From: Longridge Town Council <clerk@longridge-tc.gov.uk>
Sent: 13 January 2020 08:28
To: planning
Subject: 3/2019/1131 - 1 Lower Lane

In relation to the above planning application Longridge Town Council would like to make the following comments:

Existing and Proposed Ground Floor Plan

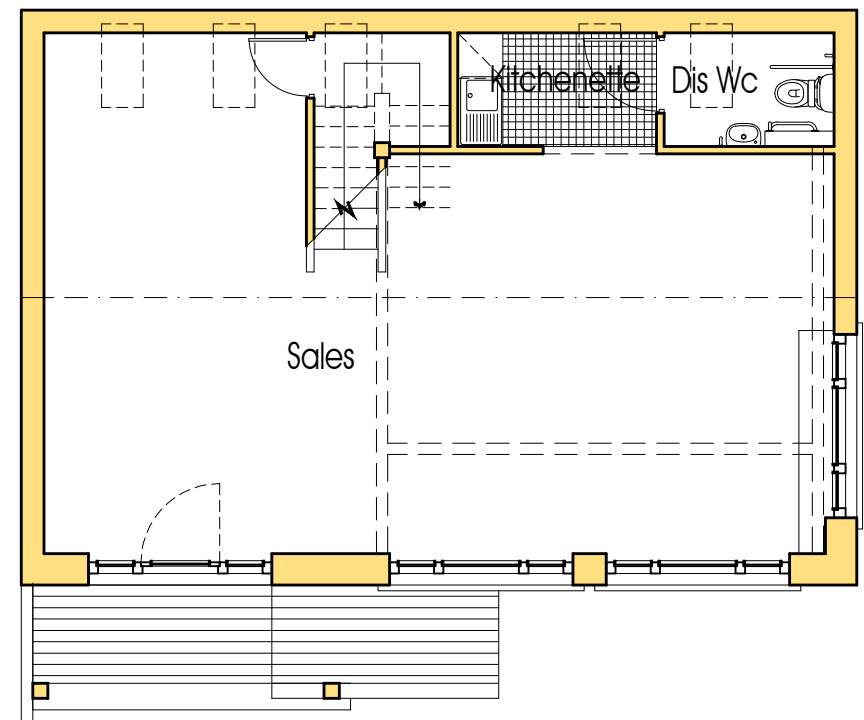
Assurances should be obtained so that the occupancy of the property does not exceed more than one person. There also appears to be no storage facility for refuse bins.
